2025/65/93234/E & 2025/48/93235/E - The Cross, Wyke Lane/Cross Street, Oakenshaw

Removal of the Cross and reinstatement within the grass verge on Cross Street/Wyke Lane (Listed Building)

WYAAS Ref: CWY507

General Site Clearance
Scale: 1:100

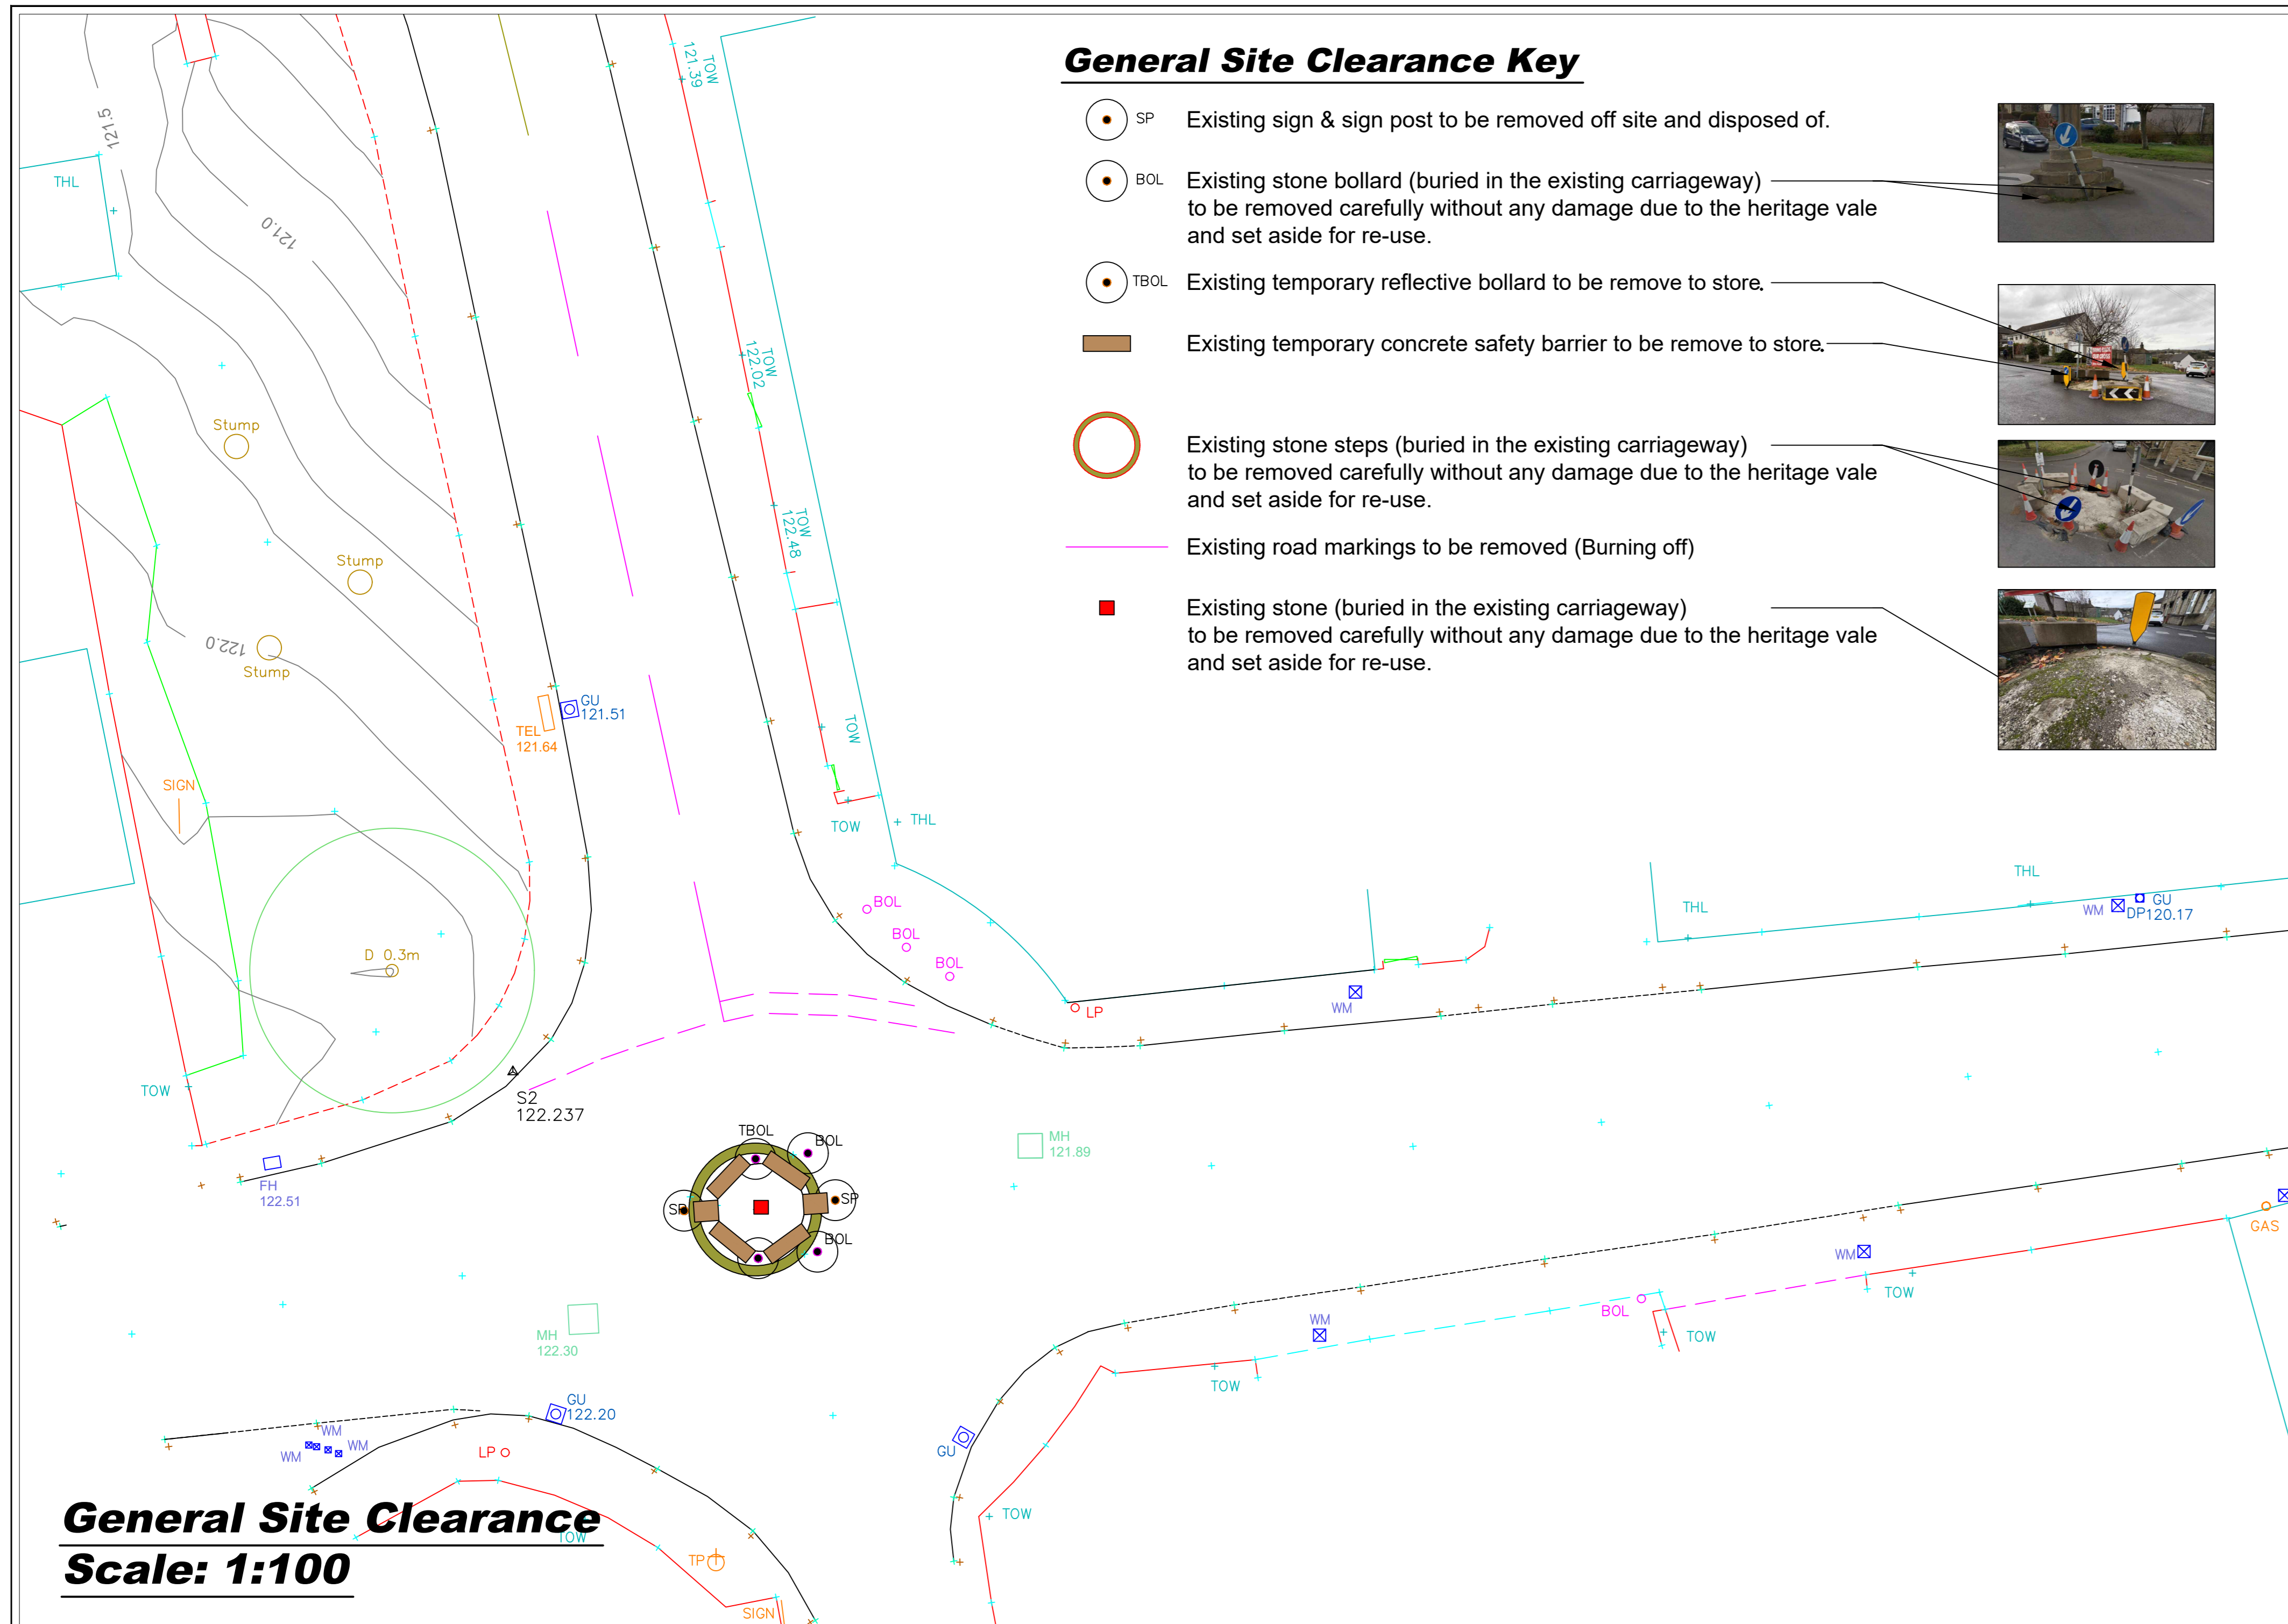
From a below-ground archaeological point of view, the ground immediately beneath the current stepped base has the potential to contain archaeological remains associated with the medieval cross. Furthermore, the highway design

details indicate that elements of the historic structure (stone steps) currently buried within the carriageway are to be removed.

A Method Statement: A detailed methodology for the dismantling, transport, and reconstruction must be agreed upon. This must explicitly address the "existing stone steps" buried within the carriageway, detailing the specific methods for their careful excavation, lifting, and storage for re-use as highlighted in the highway design notes.

An Archaeological Watching Brief: An archaeological watching brief must be maintained during these works. This must specifically focus on the recovery of buried fabric, monitoring the removal of the carriageway layers to identify and record the buried stone steps. As noted in the planning documents, these must be "removed carefully without any damage due to the heritage value and set aside for re-use." The archaeologist must ensure this process is recorded and that the fabric is safely salvaged. The watching brief must also record any underlying medieval features (such as socket stones or deposits) revealed beneath the current base once the lower stones are lifted and monitor the excavation of foundations at the new location to record any archaeological deposits disturbed.

"No demolition/development shall take place/commence within the area indicated until the applicant, or their agents or successors in title has provided a written scheme of archaeological investigation (WSI) and this has been [submitted to and] approved by the local planning authority in writing. For land that is included within the WSI, no demolition/development shall take place other than in accordance with the agreed WSI, which shall include the statement of significance and research objectives, and
